Application No: BR/286/20/HH
Site Address: 17 Shelley Road Bognor Regis PO21 2SL
Description of works: Removal of existing garage and erection of single storey side and rear extension

Thank you for your internet representation made on 5th December 2020 which has been recorded as an objection with the comments as follows:

Proposed

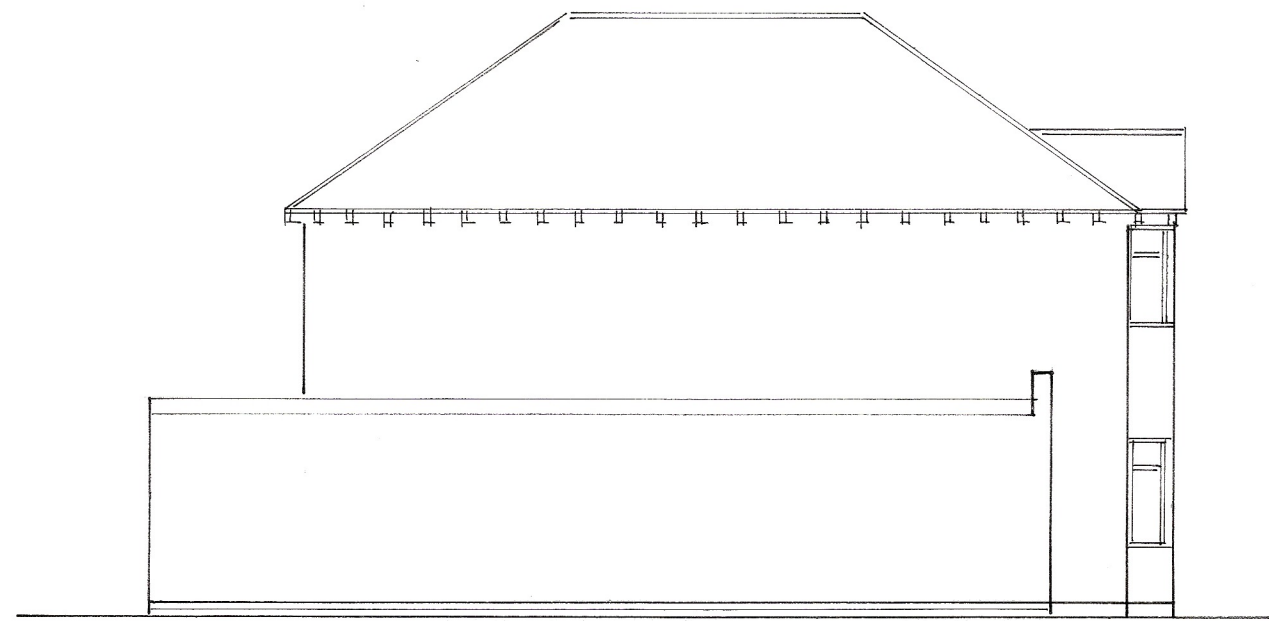
This dwelling will take my light away from my dining room and kitchen, the garage has a pitch at the moment, not a flat raised roof
